Agent Ref 10029605 -PM Mawer, Company land owner Ref 10029604 -Glendon Estate,
Company Director Ref 10029606-CJ Marshall
Land belonging to Glendon Estate, Barmston, Drifffield – Yorkshire and Humber CCS pipeline
proposal for DCO

WRITTEN REPRESENTATION

**Application for Development Consent Order (DCO)
YORKSHIRE & HUMBER CCS CROSS COUNTRY PIPELINE
EN070001**

DRG No 10-2574-PLN-01-1049

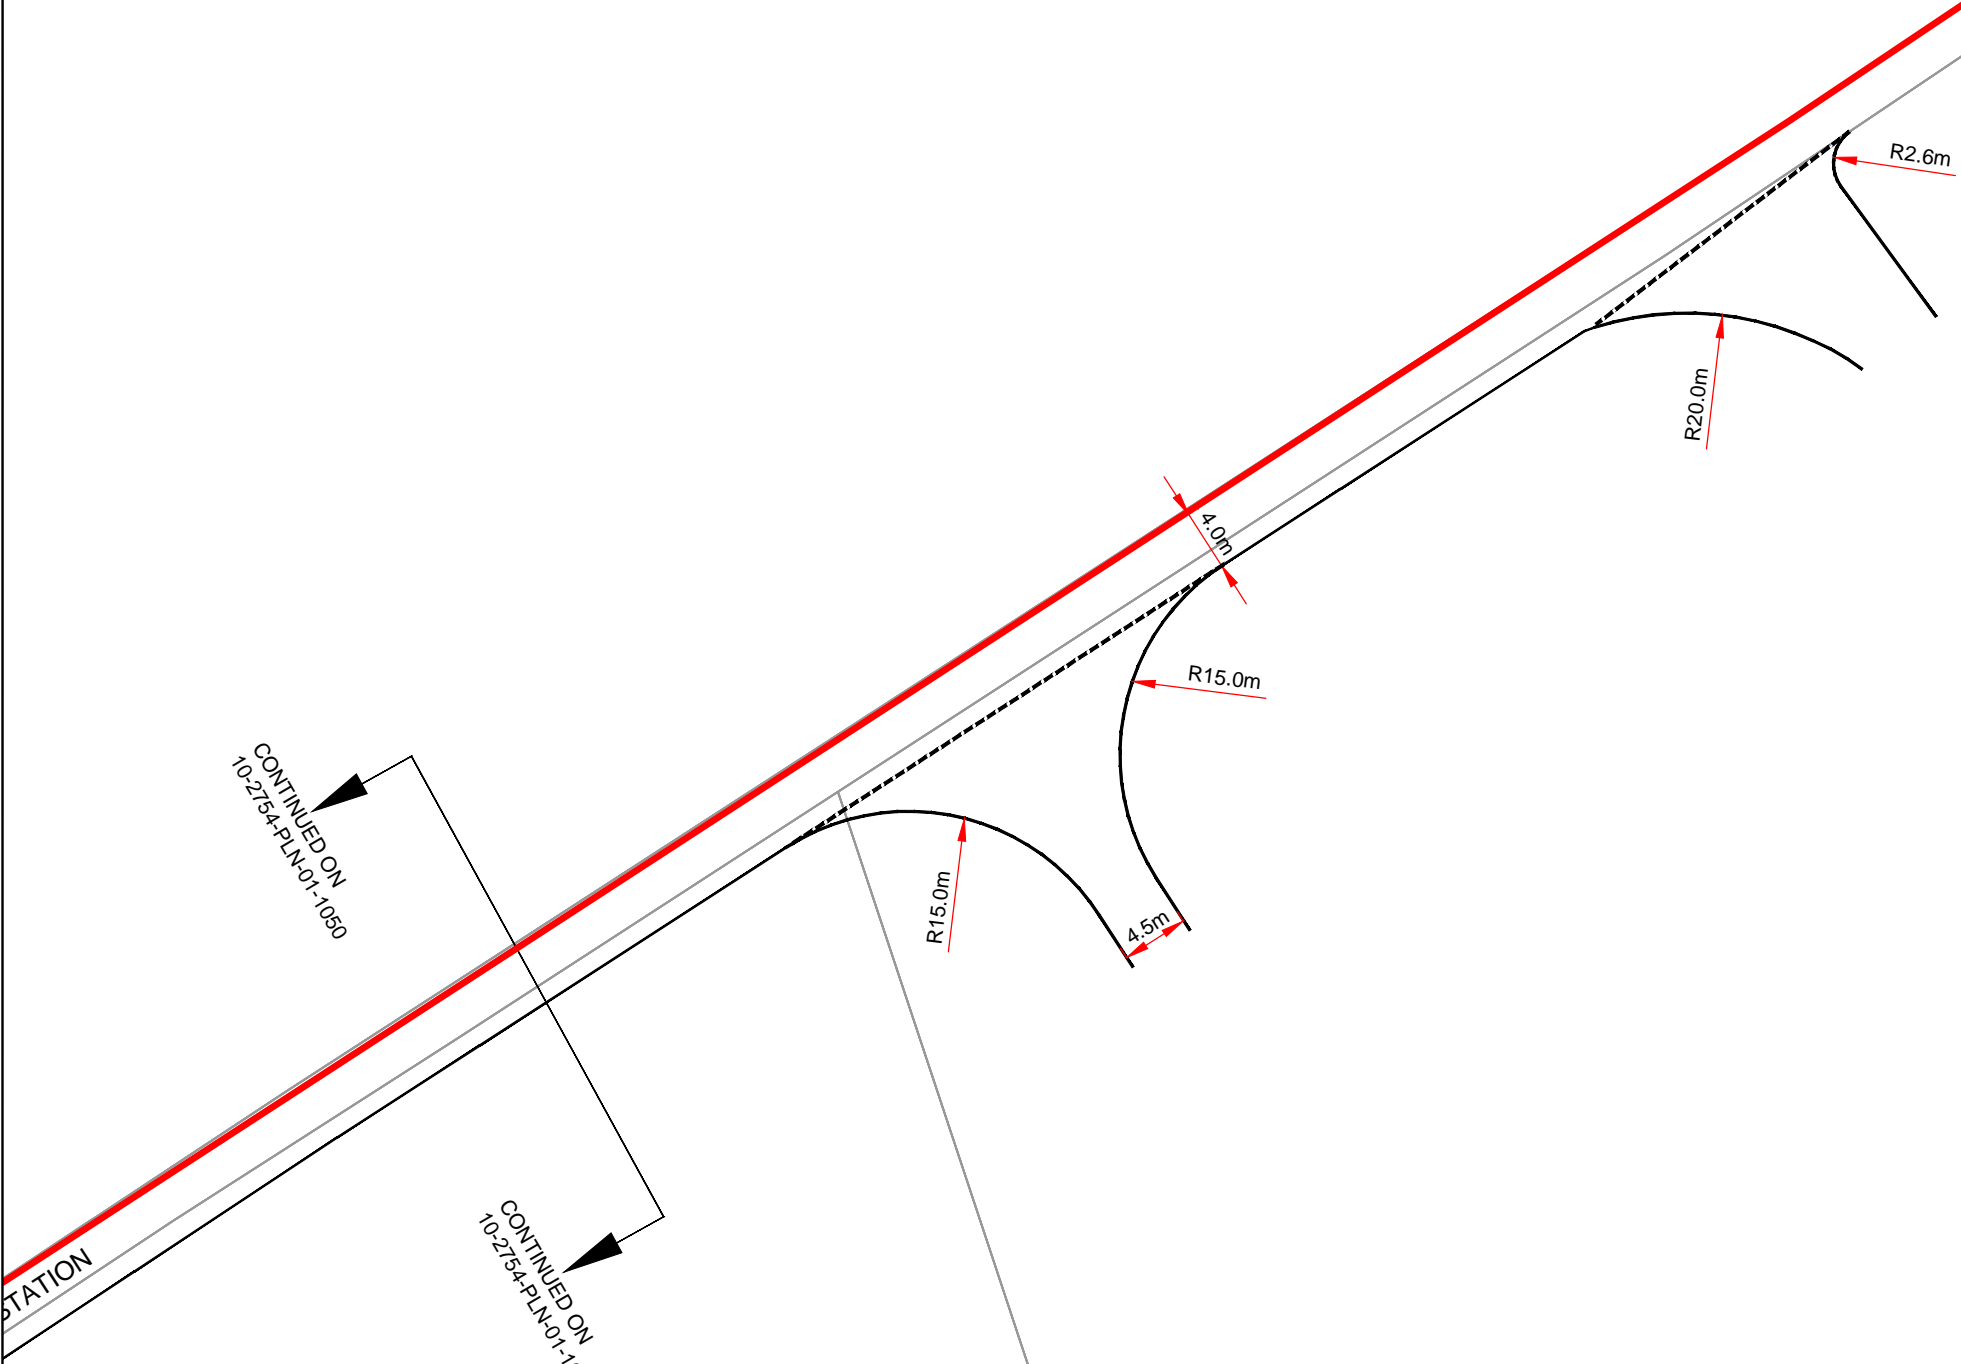
- The Developer has moved the Pumping station site at the request of the landowner to arrive at the proposal location.
- One of the reasons for this suggestion was that the site would be nearer a public road for construction access purposes (the 'back' road to Fraisthorpe village) being accessible directly from the A165

- Despite this being a single track road the distance between hedges is sufficiently wide to install temporary or permanent passing places along its length and visibility at the Highway junction is likely to be better than the proposal access.

- The proposal requires access for all heavy construction traffic along the working strip to be taken for the pipeline route between the A165 and the proposed pumping station

- This means that heavily laden vehicles and heavy machinery will access the Pumping station site across agricultural land with surfacing works to try and prevent such heavy traffic from becoming bogged down

- The weight of such traffic will have serious and long reaching implications for soil structure along this part of the pipeline route once returned to agricultural use, no matter what assurances are given by the developers regarding reinstatement.

- **All construction vehicle access to the Pumping Station site should be via the single track public highway from the A165 at the junction nearest Stonehills Cottages with suitable improvements to passing places added by the developer where necessary.**
